My comments are related to the applicant's responses to written representations at Deadline 1 addressing HYD-003 for Lavendon. My submission contests both the applicant's response and provides additional supporting evidence that the applicant has not, in my opinion, adequately taken into consideration statutory and engineering assessment in sufficient detail to draw their conclusions made for flood risk assessment for Site G

RESPONSE TO APPLICANT'S RESPONSES TO WRITTEN REPRESENTATIONS AT DEADLINE 1 : HYD-003 – LAVENDON

Title:
Figure 8.1.5 Site Locations and Study Area
Green Hill G

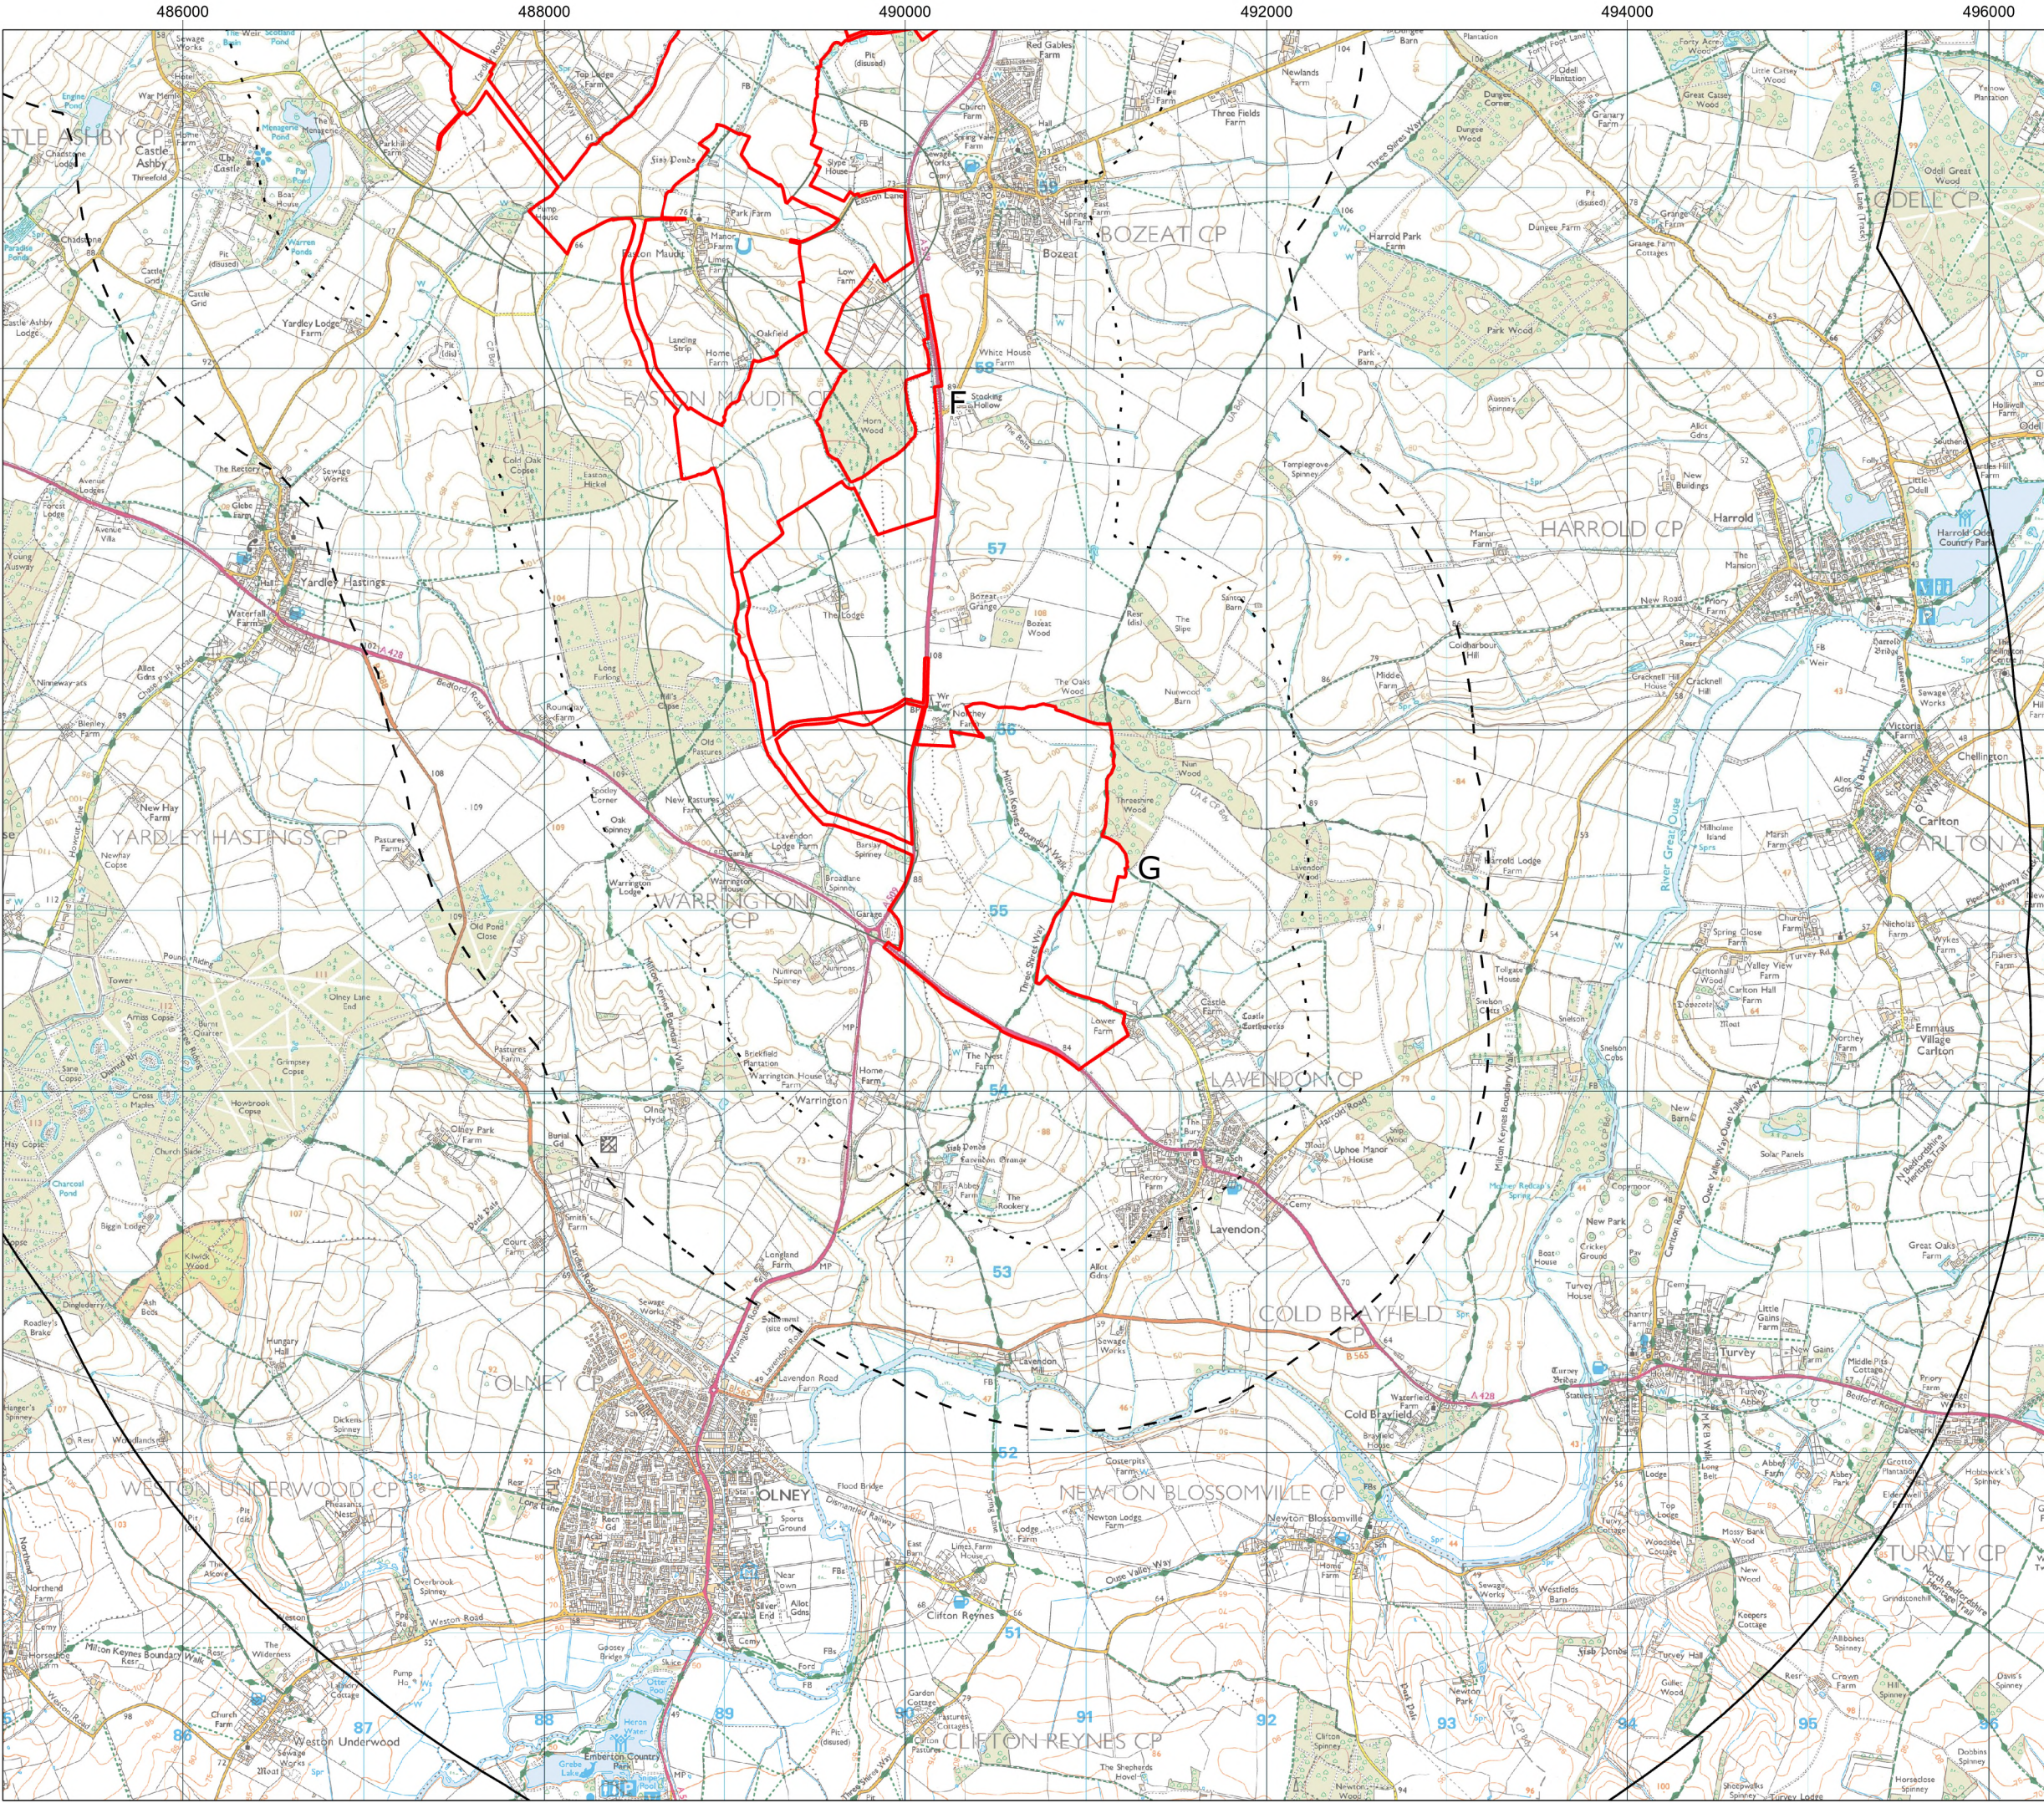
Clause 10.6.88 : According to the EA’s updated Flood Map for Planning, the entirety of Green Hill G is situated in Flood Zone 1 with the exception of a limited area within Field GF13 which is identified as being in Flood Zone 3 (*please reference ^[10]*), associated with a land drainage ditch and unnamed Ordinary Watercourse. However, these extents remain outside of any areas of proposed development (*please reference ^[5]*). The EA Historical Flood Map indicates that Green Hill G has not historically flooded and neither has the area nearby.

The developer states that the “entirety of Green Hill G ... with the exception of the area within Field GF13...”. As the developer has continuously used the exception to their advantage through their FRA and relied on the bigger picture for their assessments, this by no means relieves them of their responsibility to address all areas that do indeed fall into the area of proposed development – especially by their own admission. The comment that “these extents remain outside of any areas of proposed development” appear to be in complete contradiction and disregard of MK’s policy referenced in ^[5], ^[6], ^[7] and ^[8]. The Developer cannot simply cherry-pick extractions to their advantage – they are bound by the entirety of policies.

The developer further states that the EA Historical Flood Map indicates that Green Hill G has not historically flooded and neither has the area nearby! If proper research had been carried out, it would have been very clear to the contrary. For ease of reference for the developer, a summary of verified, documented flood events in Lavendon that were included in the independent report are shown in the following timeline:

The conclusions drawn in Clause 10.6.89 are therefore factually incorrect.

The developer's attention is drawn to the Surface Water Flood Risk comments as well as the surface water flow paths. **Three of the surface water flow paths run through sites G-9 and G-13.**

Clause 10.6.92 : As described in the fluvial section above, the surface water flooding extents largely match the courses of the land drainage ditches.

I cannot understand how a statement of “largely” is considered to be a technical or engineering term. How is “largely” defined by the developer? This appears to be reminiscent of a comment that the developer dismissed from the Lavendon representative commenting on the proposal as “relying on simplified assumptions”.
